**SSD-10365 St Francis College Stage 1 - Landscaping**

Thank you for your correspondence via Major Projects Planning portal (ref: PAE-3795) on 30 June 2020, requesting Transport for NSW (TfNSW) to review the subject matter.

Figure 2.1: Proposed Car Parking Layout

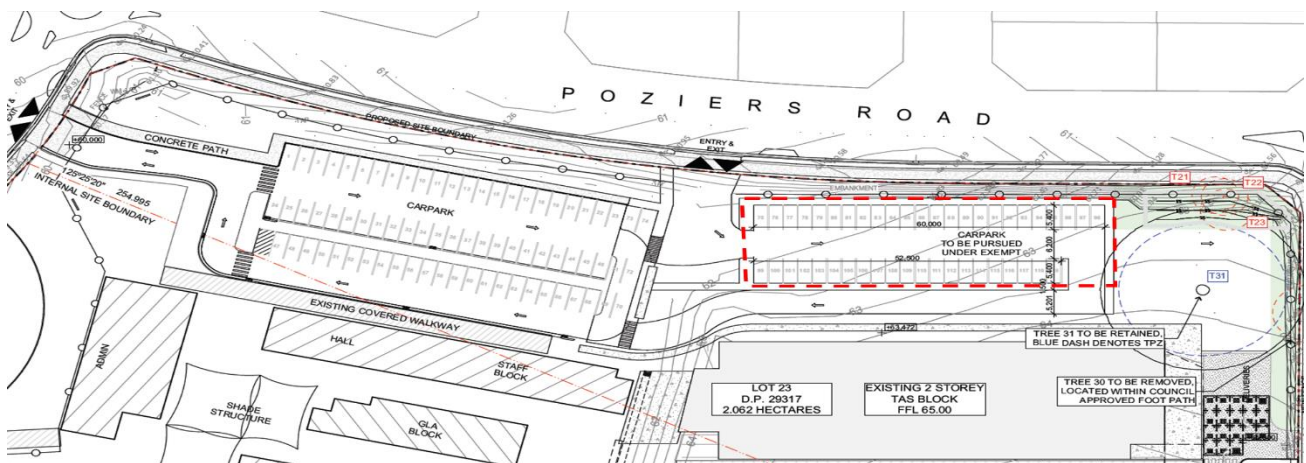
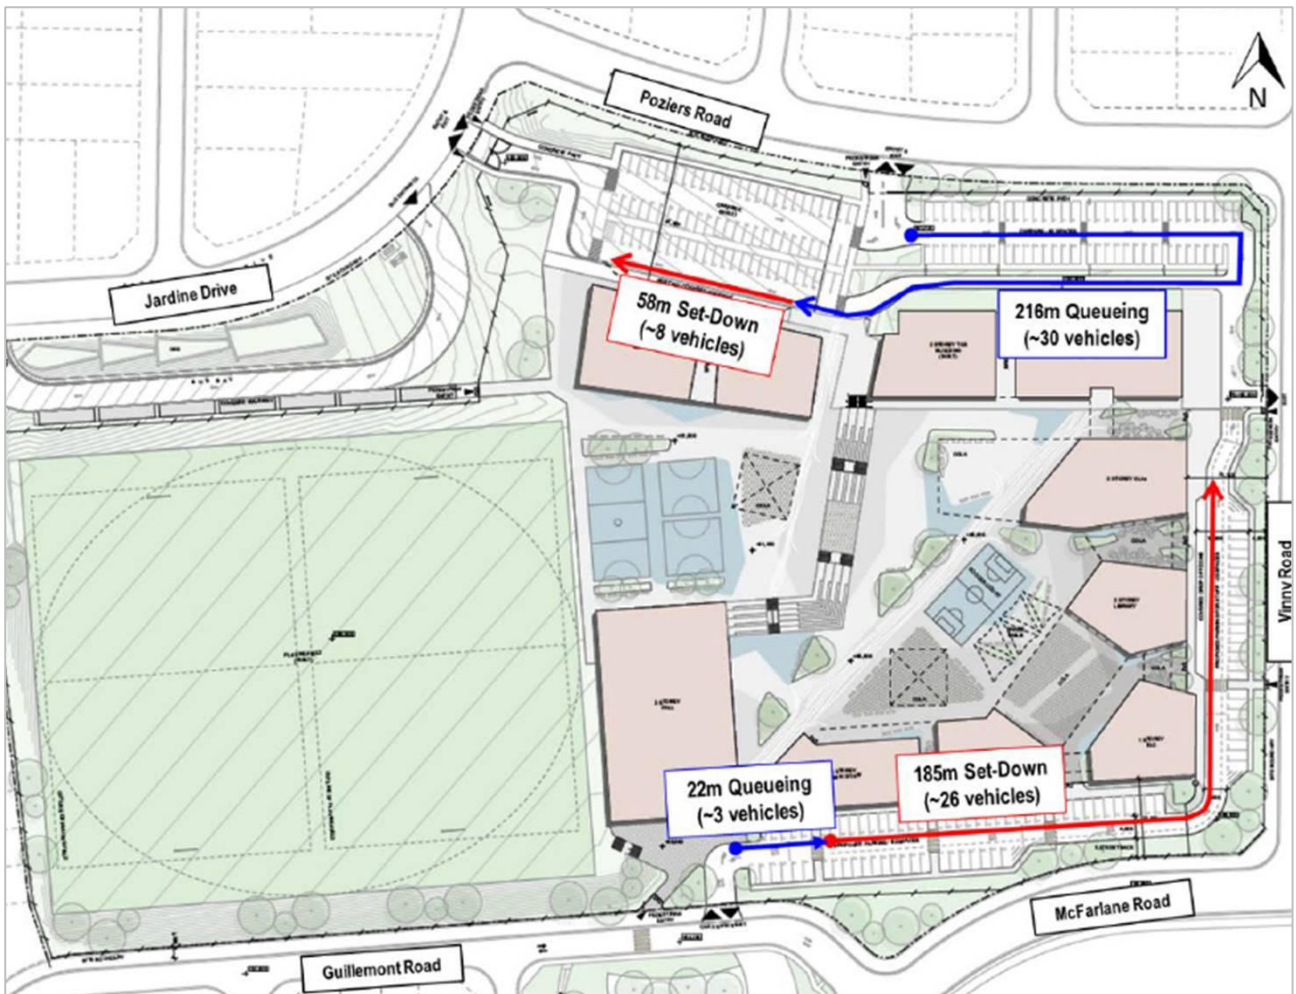
It is noted that a revised queuing assessment has been undertaken for the pick-up and drop-off arrangement as part of the development application. However, no safety assessment has been undertaken for the student movements between parked cars and reversing cars into parking spaces to access pick-up and drop-off area as 185m long pick-up and drop-off area within the car park extends beyond the pick-up and drop-off bay.

It is requested that the applicant be conditioned to undertake a Road Safety Audit for the school pick-up and drop off areas, prior to the issue of the construction certificate, in accordance with *Austroads Guide to Road Safety Part 6: Managing Road Safety Audits* and *Austroads Guide to Road Safety Part 6A: Implementing Road Safety Audits* by an independent TfNSW accredited road safety auditor. Based on the results of the road safety audit, the applicant shall implement safety measures, if required.
